Rezoning Transportation Analysis

Petition Number: 2020-125

General Location Identifier: Tax ID 05112203

Date	Description
10-26-20	First Review

**RZ-1.0**

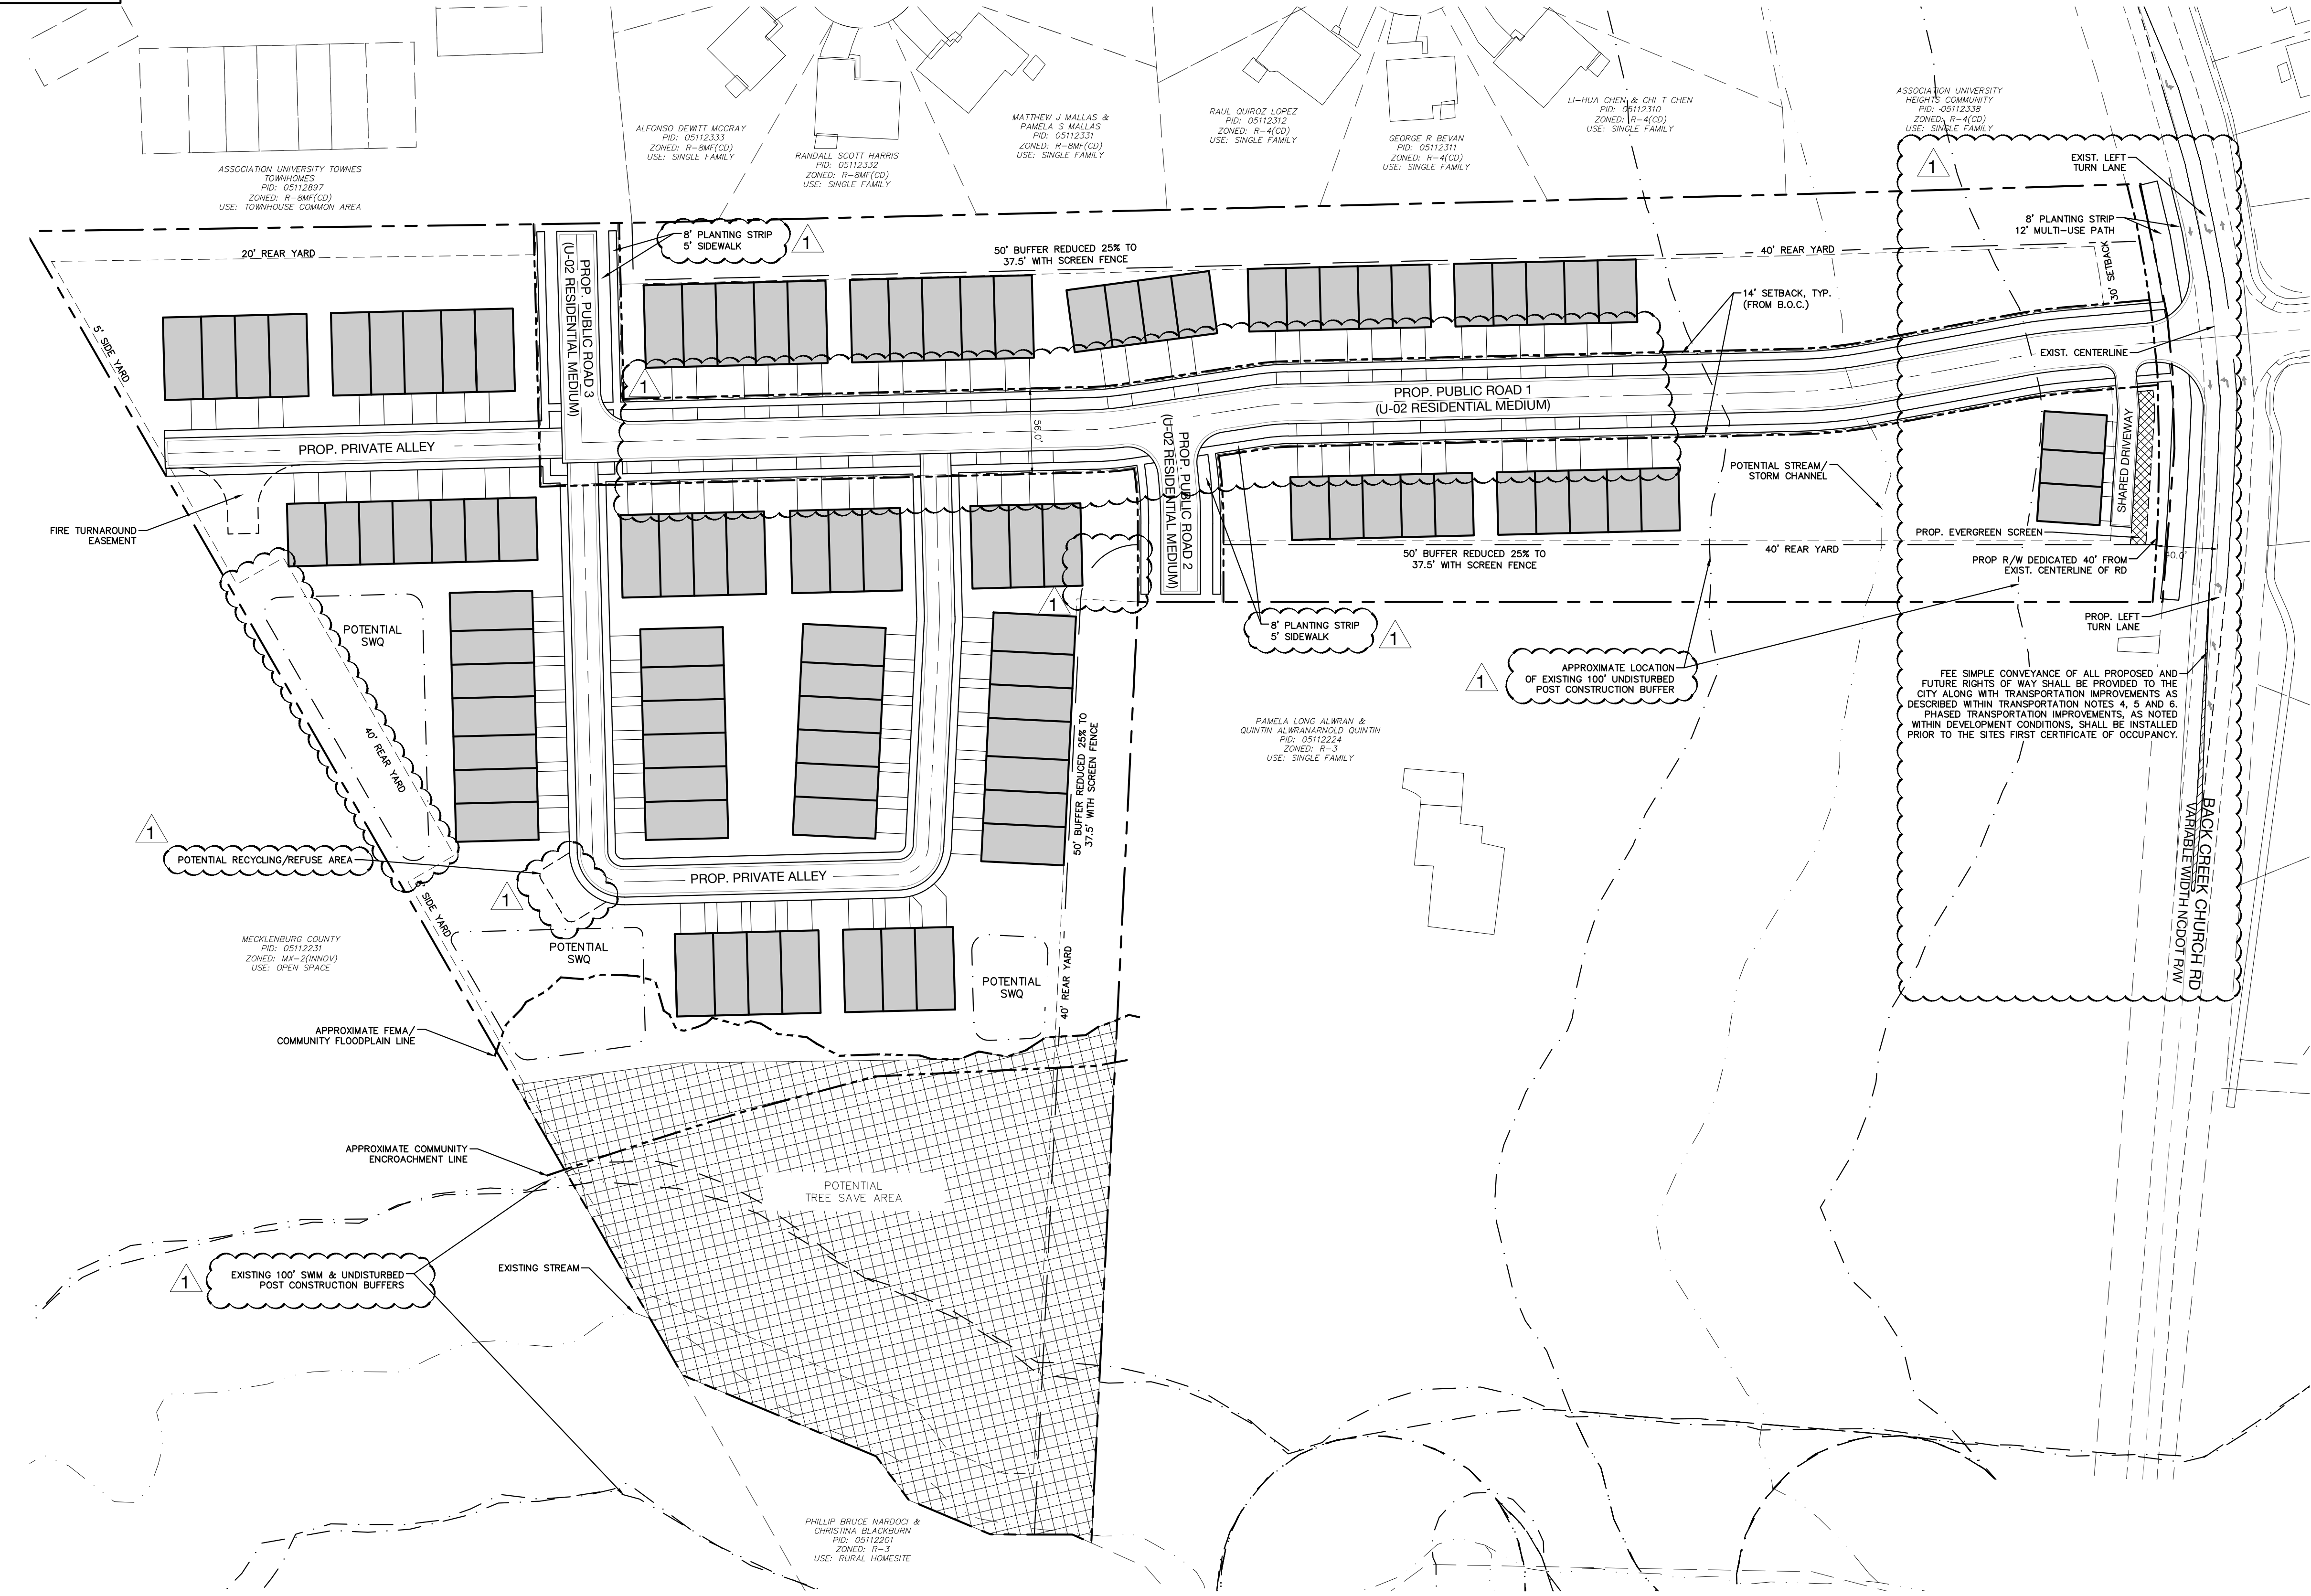
Site plan revisions are needed to meet ordinance requirements and the outstanding items include, but are not limited to: labeling and dimensioning the 6-foot sidewalk with 8-foot planting strip on all local roads per Chapter 20, installing a 12' multi-use path along Back Creek Church Road to meet the City of Charlotte BIKE Policy, and providing a left turn lane into the development as required for developments that generate over 500 trips per day. CDOT also requests that the petitioner provide alley-loaded townhomes along public streets OR provide shared access driveways to help produce a more organized and pedestrian-oriented form of access management for consistency with the Driveway Manual. Further details are listed below.

- Curblin**e: The proposed zoning district has a setback measured from back of the existing or proposed future curblin
- Back Creek Church Road**: The back of curb and gutter shall be located at 19' from the roadway centerline. This accounts for two 11' through lanes, 2.5' curb and gutter, and an 11' left turn lane at the site's entrance.

The site plan should show the curb and gutter labeled and dimensioned from the centerline for each road.
- Traffic Study**: A Traffic Impact Study is not necessary for the complete review of this petition due to the site generating less than 2,500 daily trips. If during the permitting process the site generates more than 2,500 daily trips, then a traffic study will be required.
- Revise the site plan and conditional note(s) to commit to dedicating 40' minimum right-of-way from the Back Creek Church Road centerline. The site plan shall label and dimension the right-of-way from the road centerline.
- Revise the site plan and conditional note(s) to commit to constructing an 8-foot planting strip, and 6-foot sidewalk on all Local roads per Chapter 20 and CLDSM Standard U-03. While the site plan shows both, they need to be labeled and dimensioned accurately from the back of curb and gutter.

- 5. The site plan and conditional note(s) revisions are needed to commit to installing a 12' multi-use path along Back Creek Church Road to meet the City Charlotte BIKE Policy.

6. Revise the site plan and conditional note(s) to commit to providing a left turn lane into the development as required for developments that generate over 500 trips per day, as per NCDOT's policy on street and driveway access.

7. The proposed driveways do not meet the minimum spacing requirement of 20' per the City of Charlotte Driveway regulation. Revise site plan and conditional note(s) to commit to constructing alley loaded homes along public roads **OR** provide shared access driveways to help produce a more organized and pedestrian-oriented form of access management per the City of Charlotte Driveway Regulation.
